Re Project SSD-10444 – Blue Gum Community School

Please accept this as our submission on, and objection to, this proposed project.

Re: DA/1119/2019 – 1 Rosemead Road

Drawing No. A100 Revision K

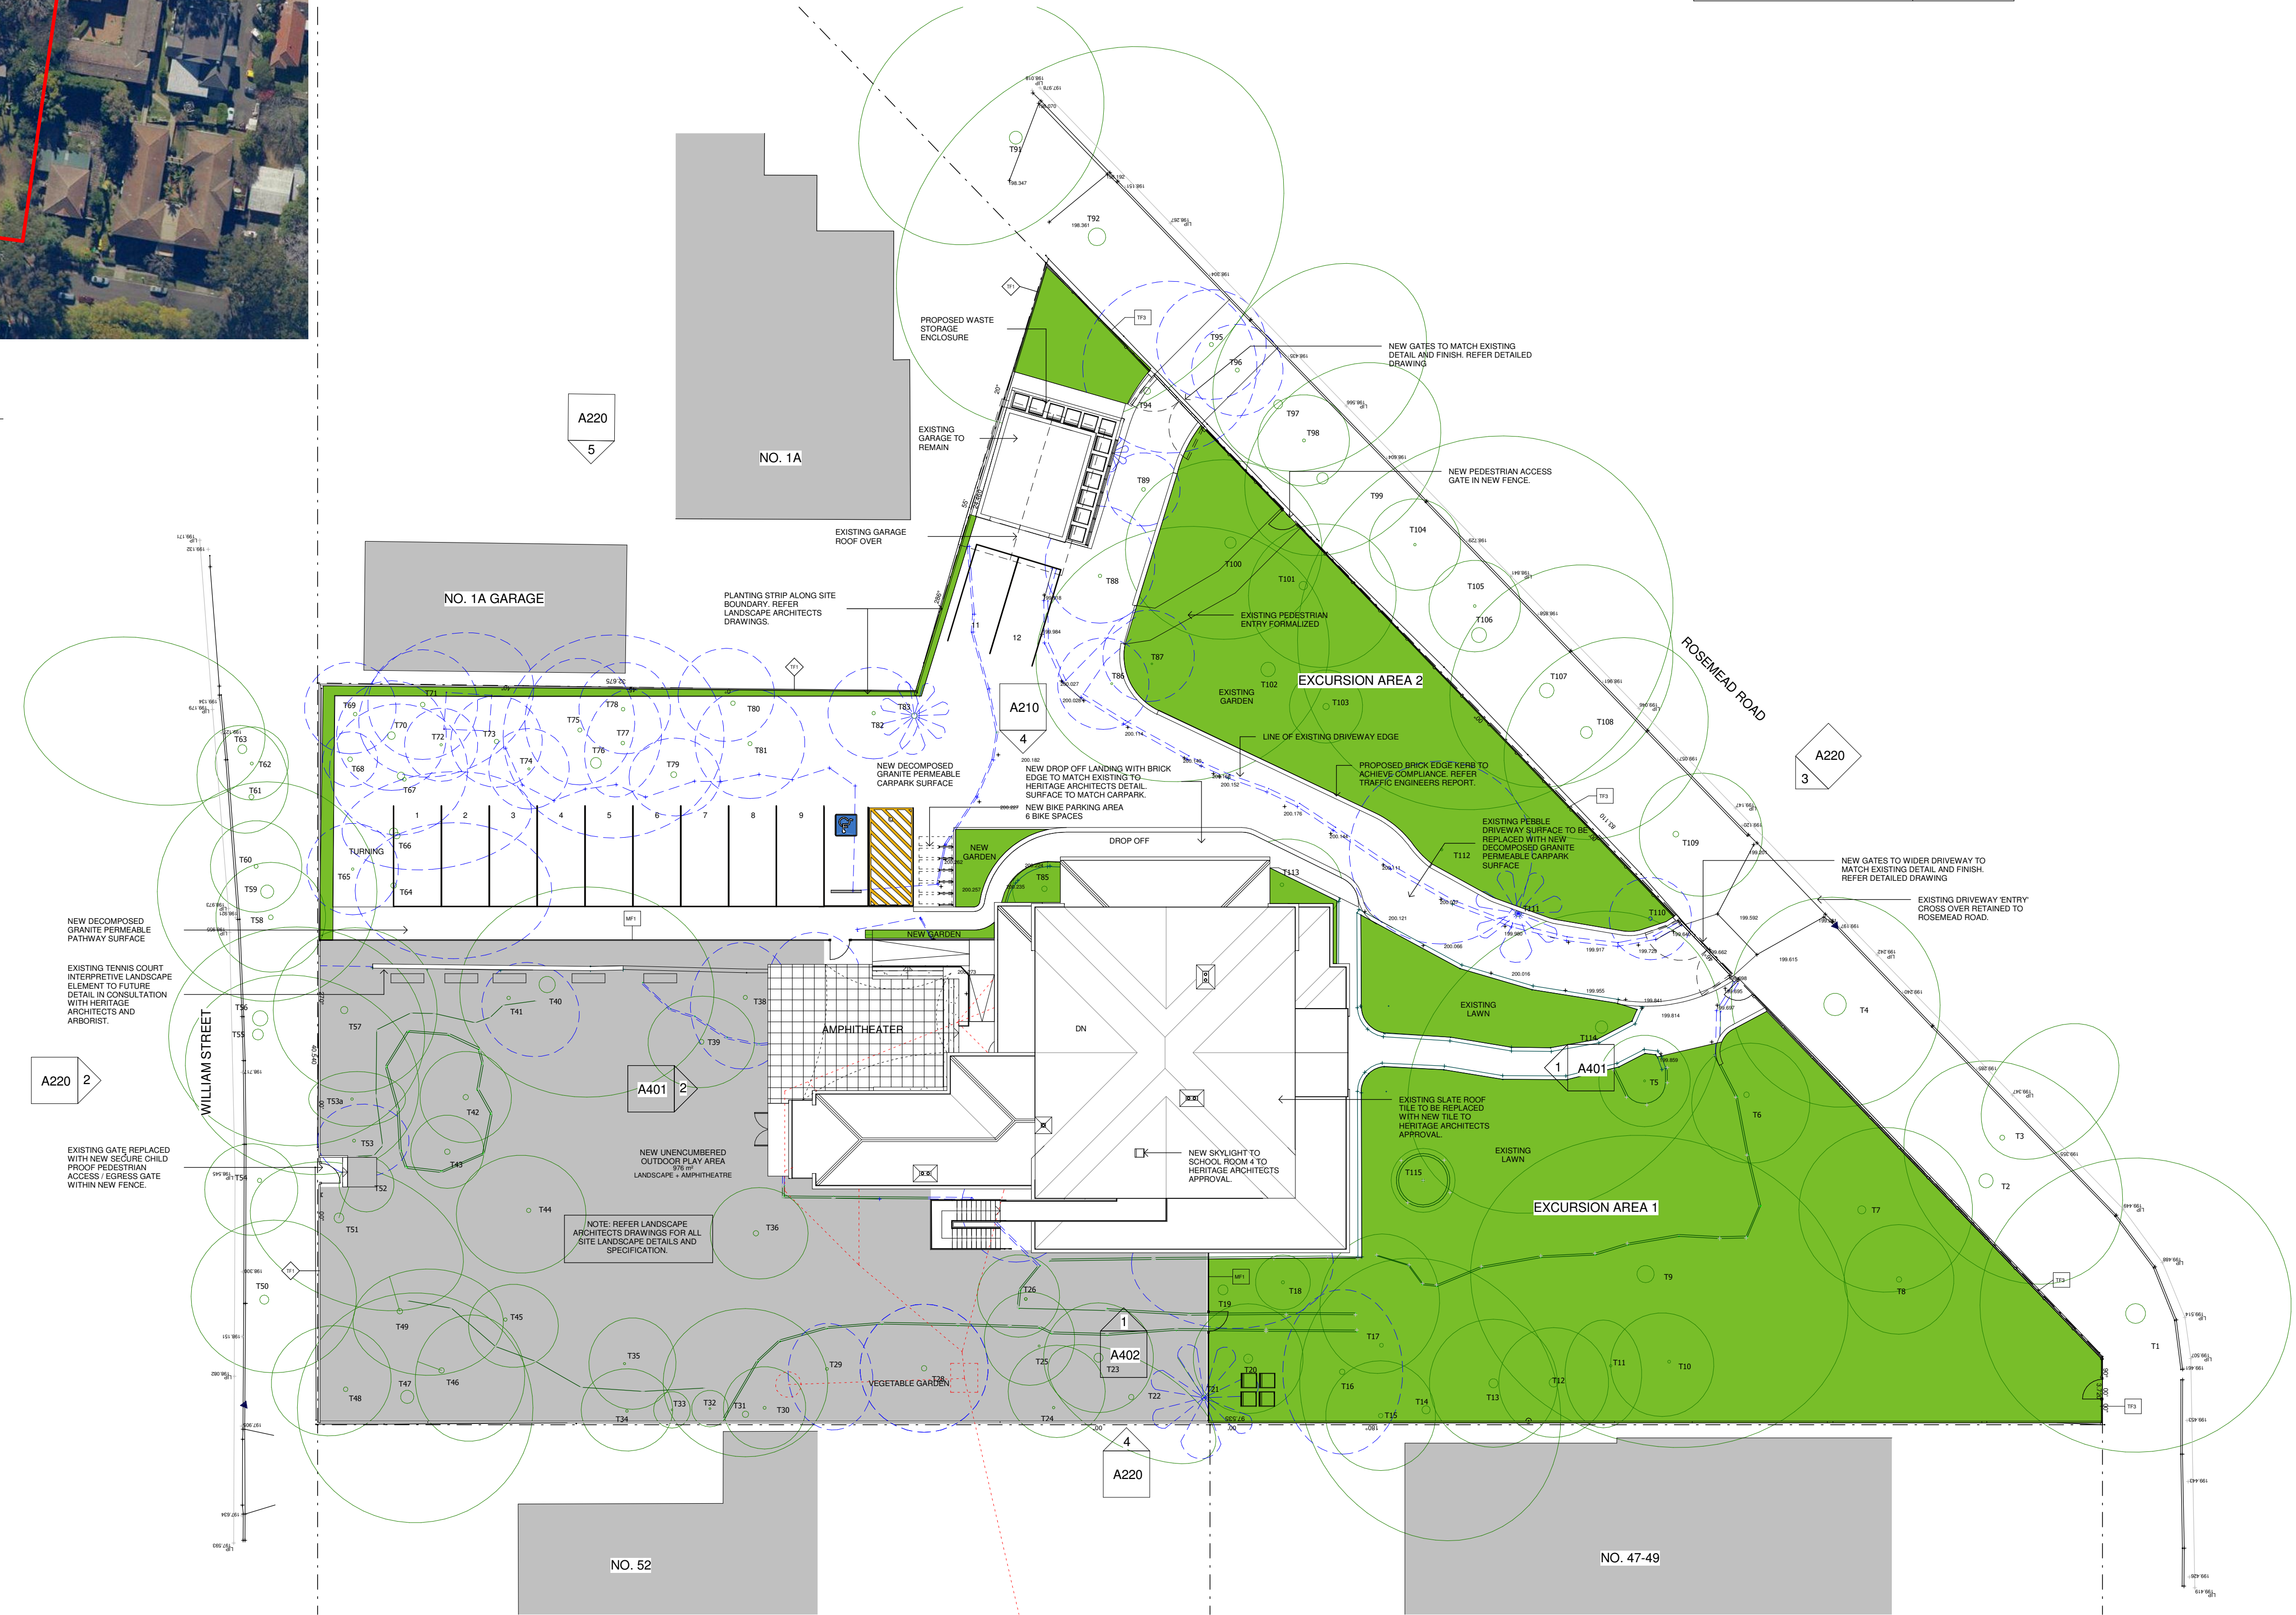
We are concerned that the existing driveway gate is to be removed. Retention of gates (and fences, where in good condition) is a specific requirement of section 9.2.4 of the Hornsby Development Control Plan 2013. The existing gate introduces and complements the dramatic view of the impressive front façade of Mt Errington from Rosemead Road and we believe its removal would be detrimental to the street view of the house.

Further, it is unclear from the Statement of Heritage Impact what is to happen to this gate. On page 54 of the Statement of Heritage Impact it is stated both that the gate (i) “would be retained and appropriately stored on site in a secured waterproof area” and (ii) “would be ... reused in the new landscaping works” (the latter understood to be at the entrance to a vegetable garden). In our view, neither of these alternatives compensates for the loss of view from the street.

We are also deeply concerned at the extent of tree removal proposed.

One large *Angophora costata* has already been removed. The Arboricultural Impact Assessment Report submitted with the Development Application lists 116 trees of varying retention values on the site. The Report identifies that 41 of these require removal. These include 5 *Eucalyptus pilularis* (“Blackbutts”) – some up to 22 metres in height. While some of the 41 trees are stated to require removal because they are diseased or damaged, the majority are proposed for removal to allow the proposed works to proceed.
